1999 INWOOD / S. QUORUM - PROPERTY ACQUISITION

January 21, 1999

Re: Inwood/S. Quorum Project

COUNTY : DALLAS
ROADWAY : SOUTH QUORUM/INWOOD CONNECTION
PARCEL : 1

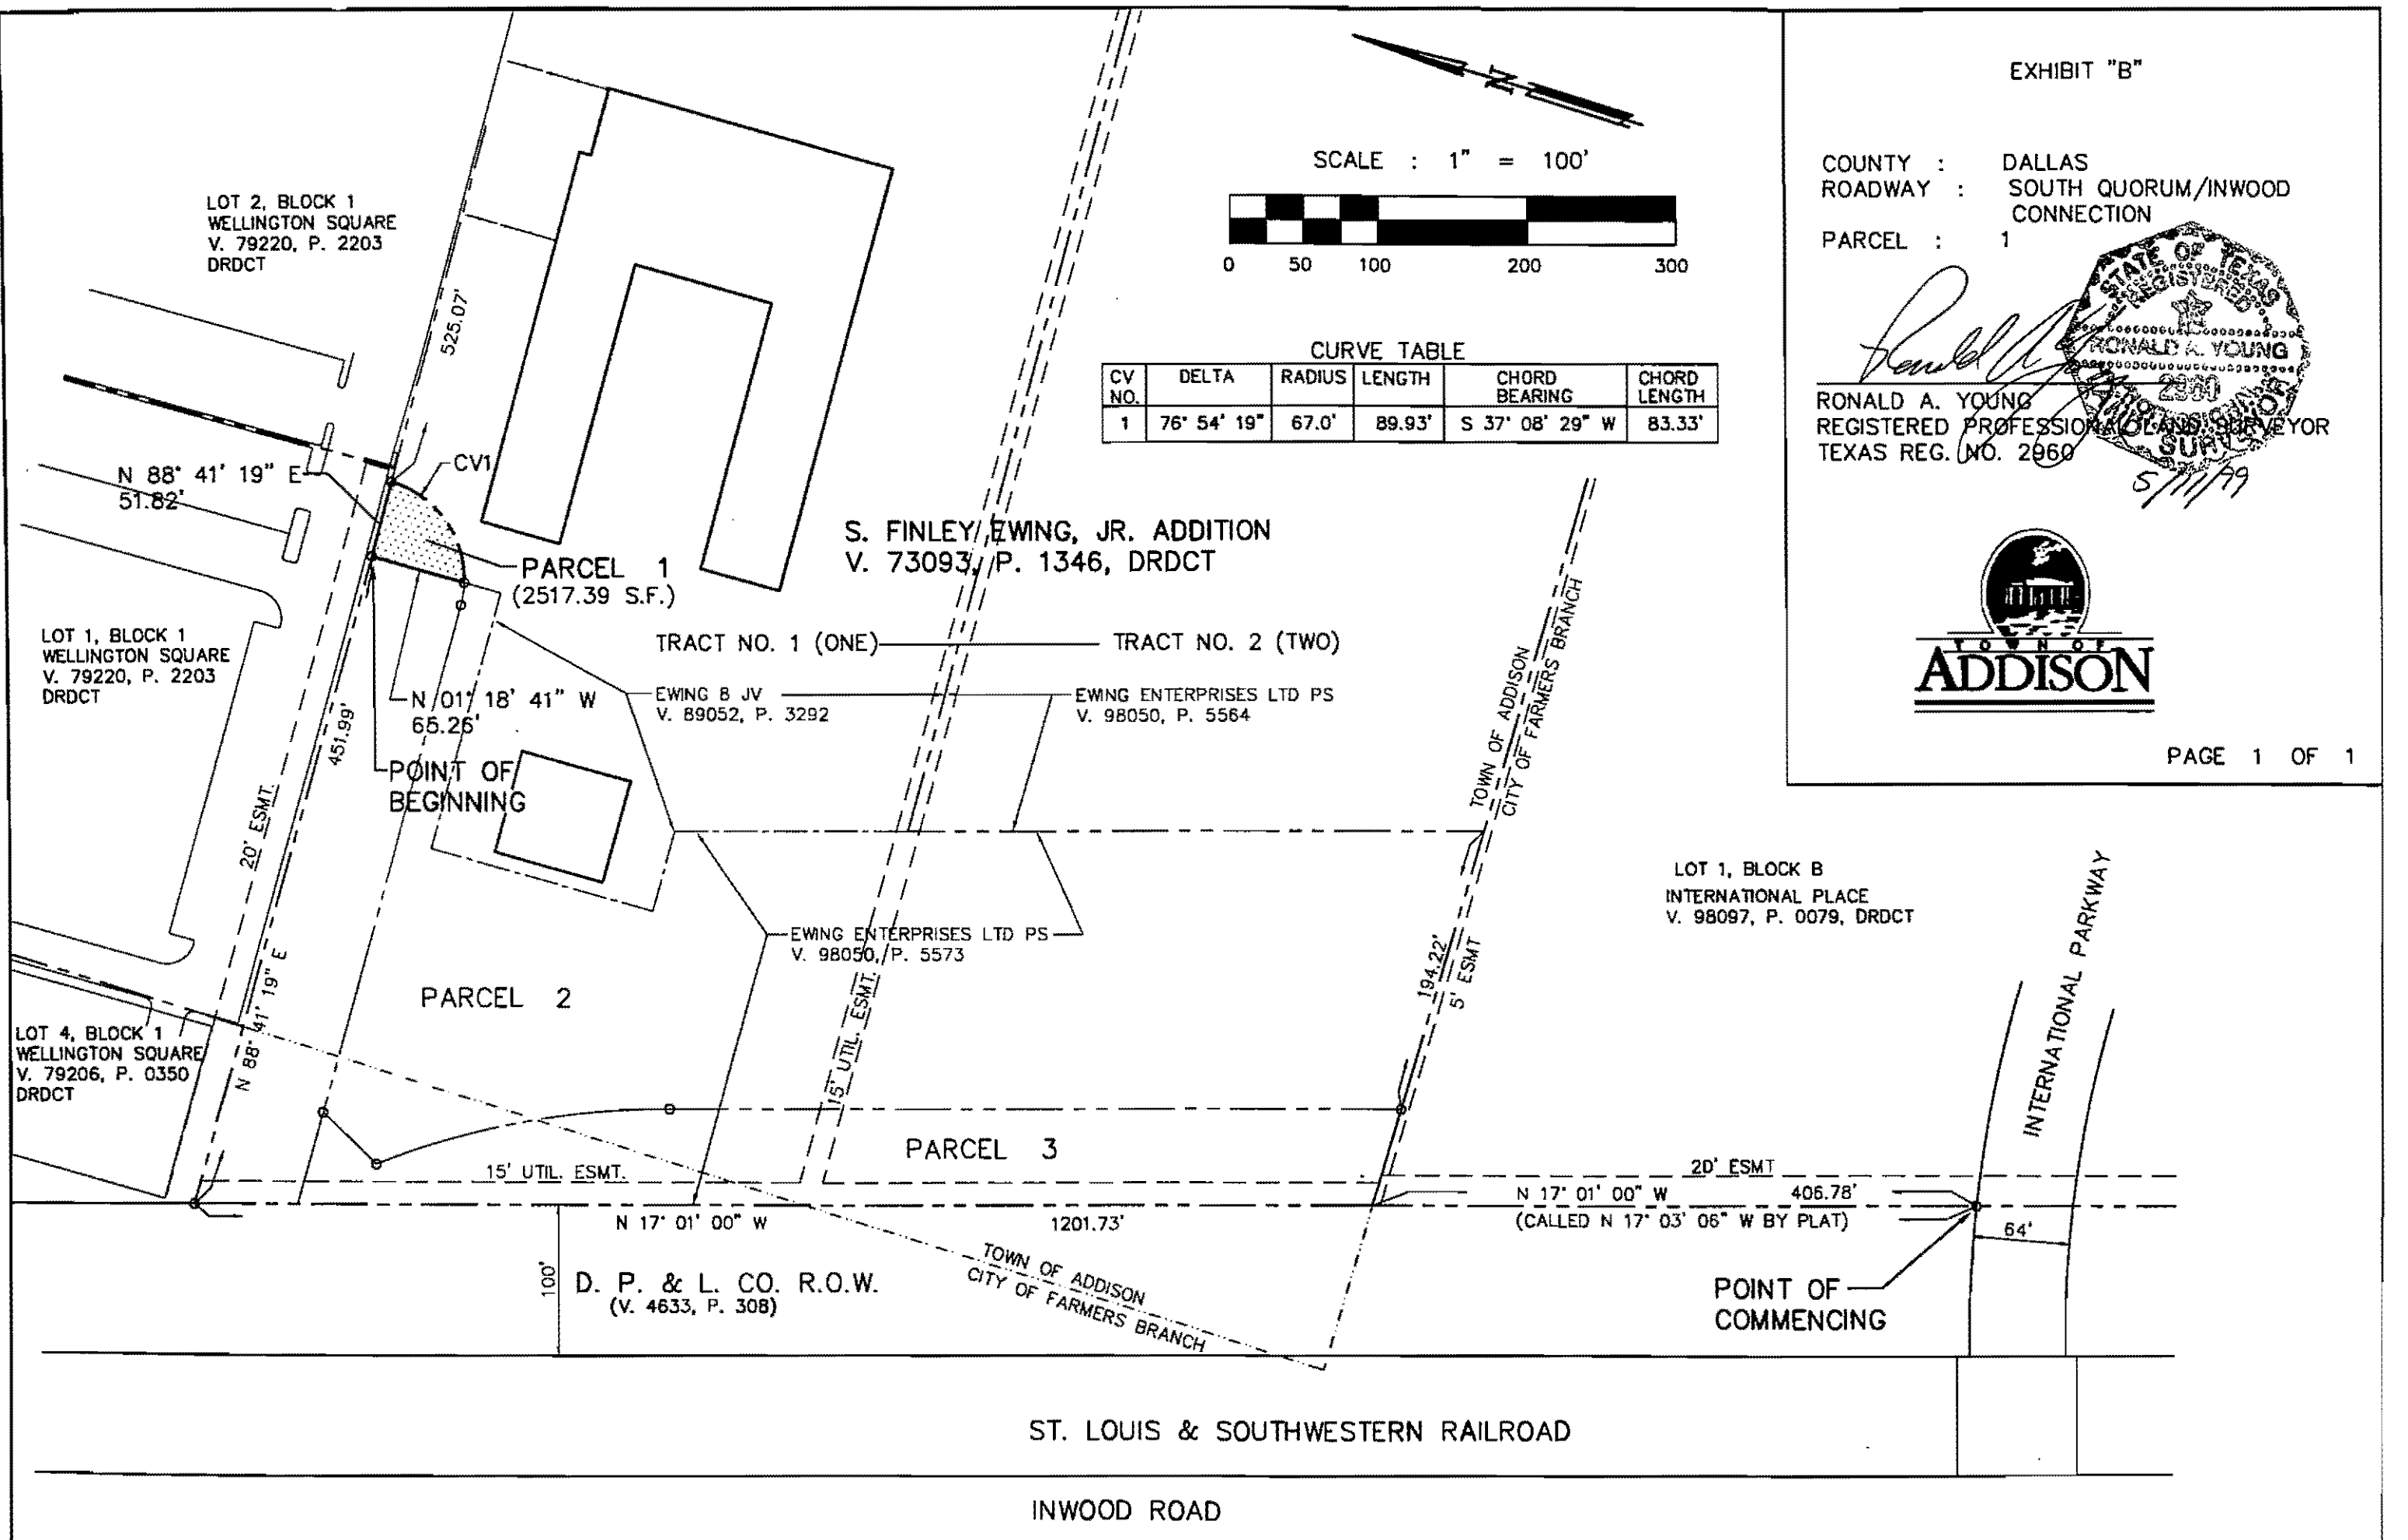
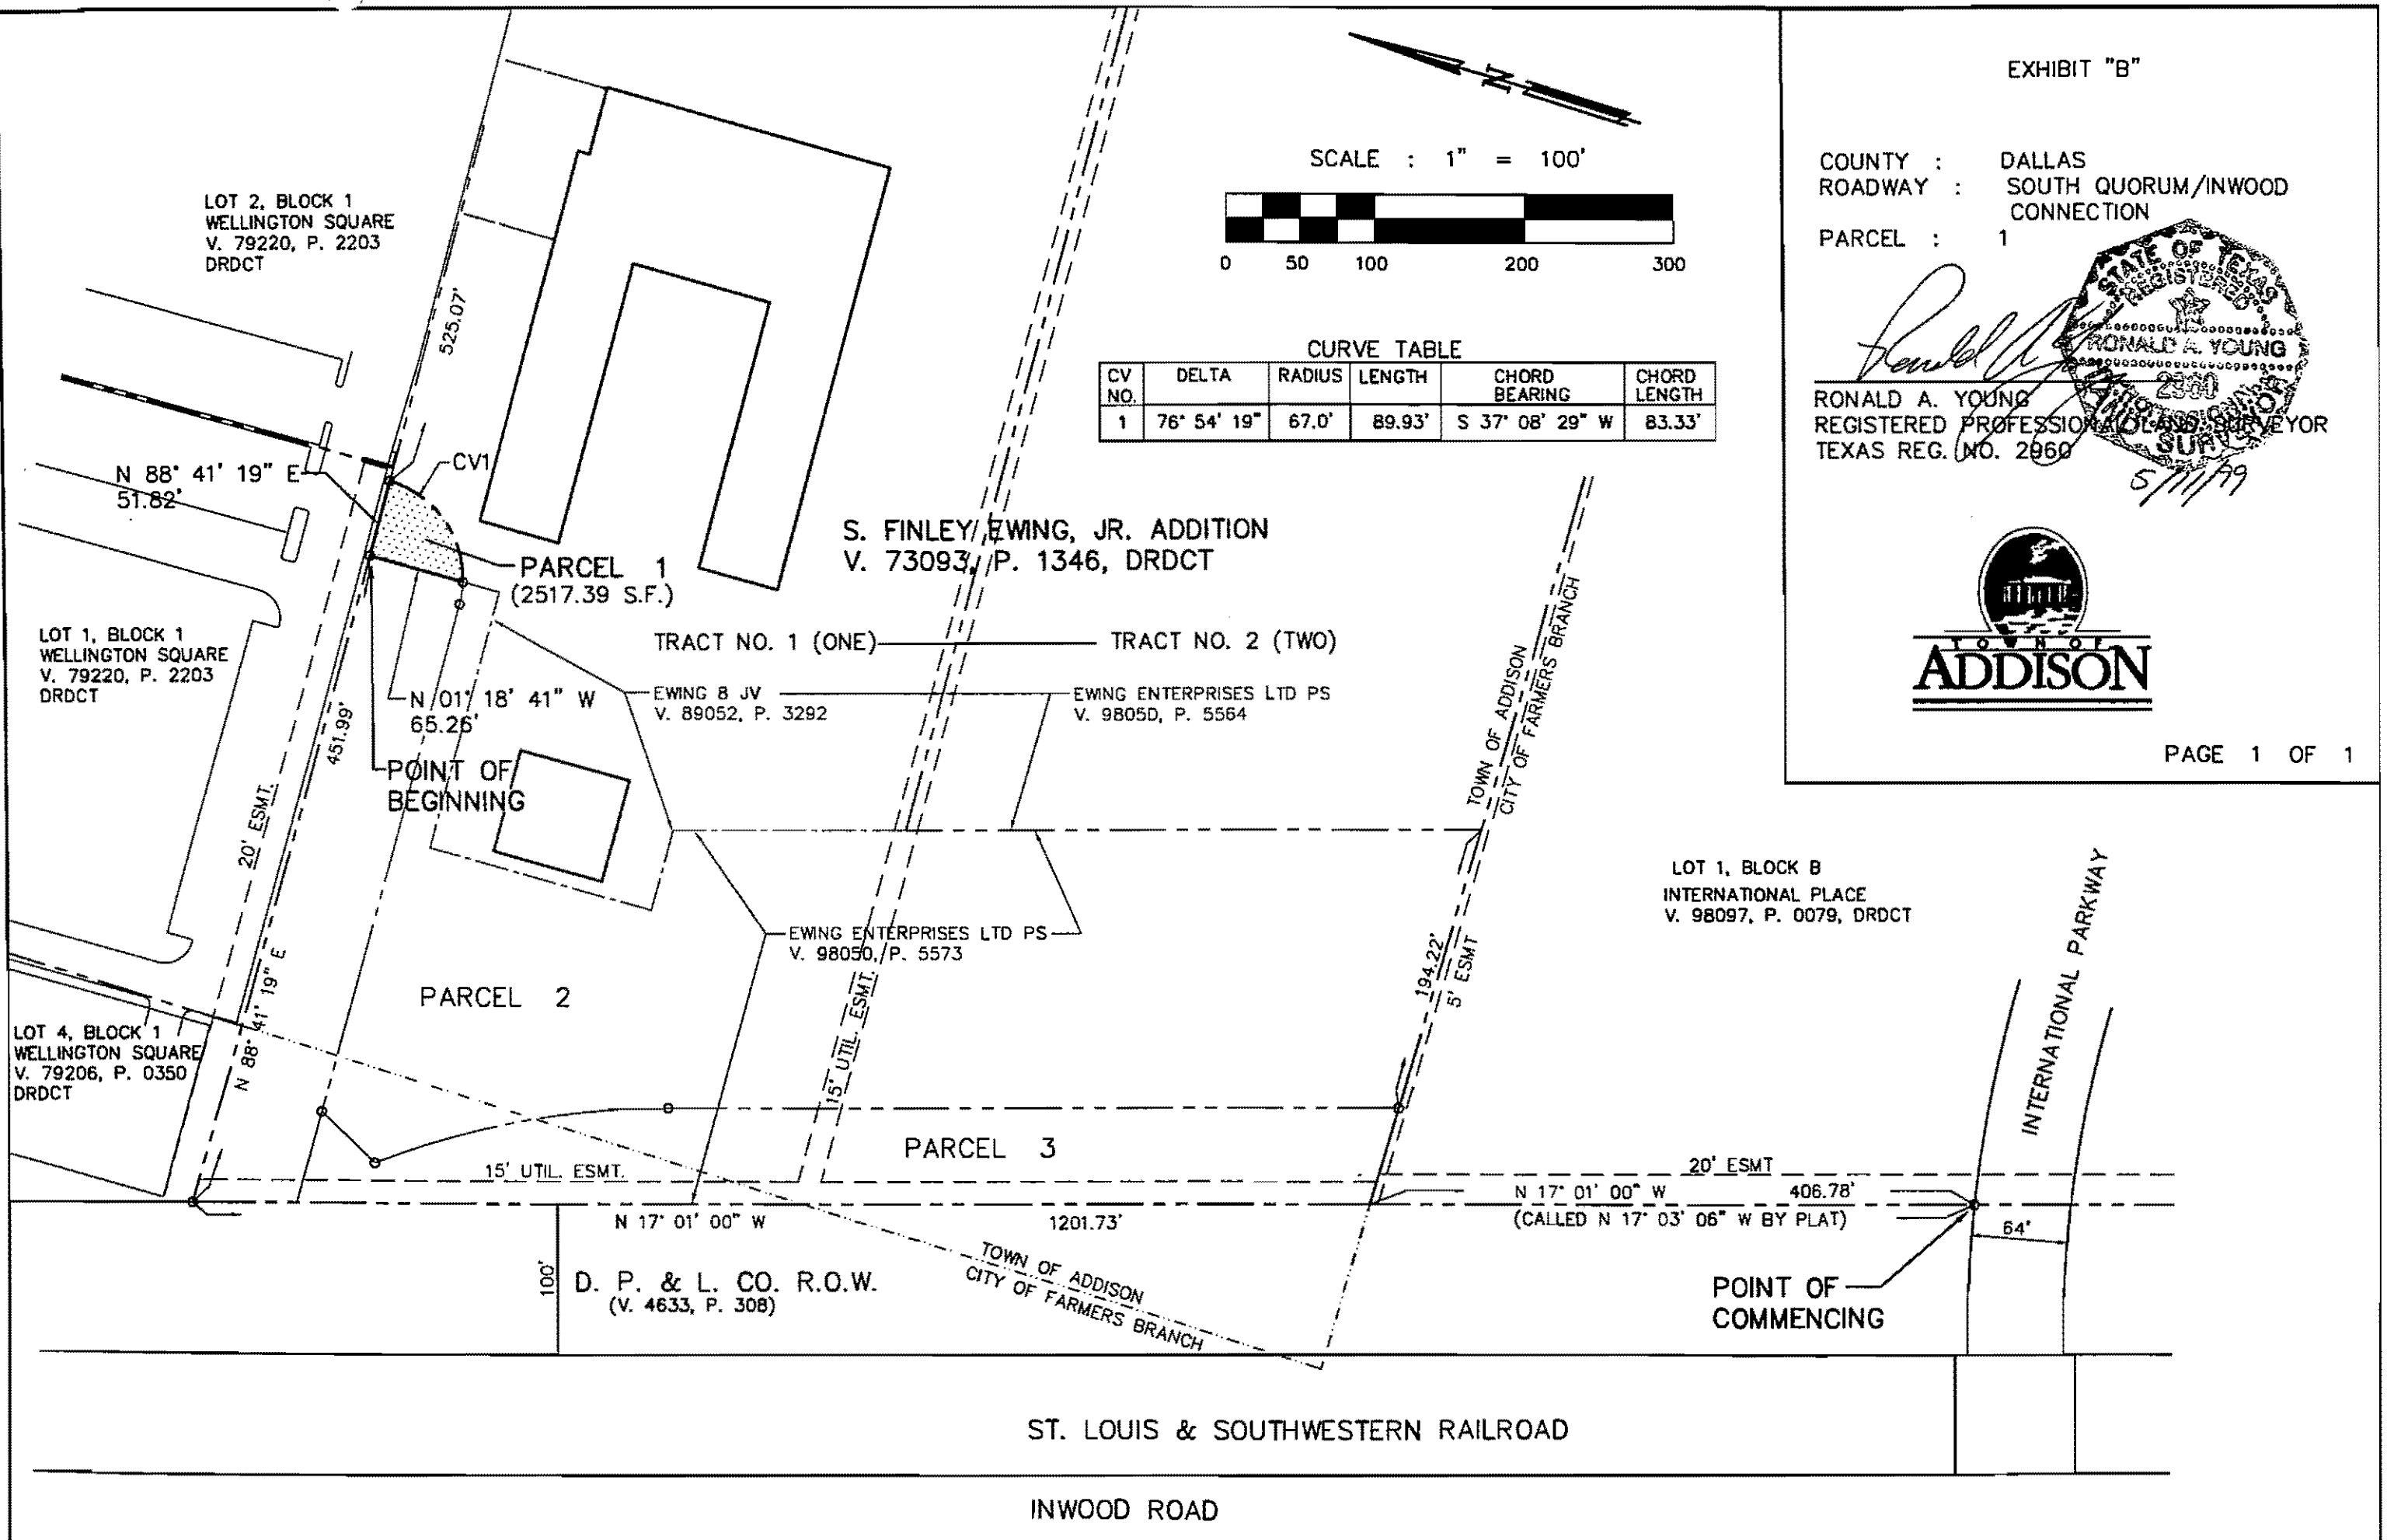
- The width of the East-West portion of Parcel 2 will be reduced by 3 feet. This will also affect Parcel 1. Parsons Transportation Group is preparing revised metes and bounds.
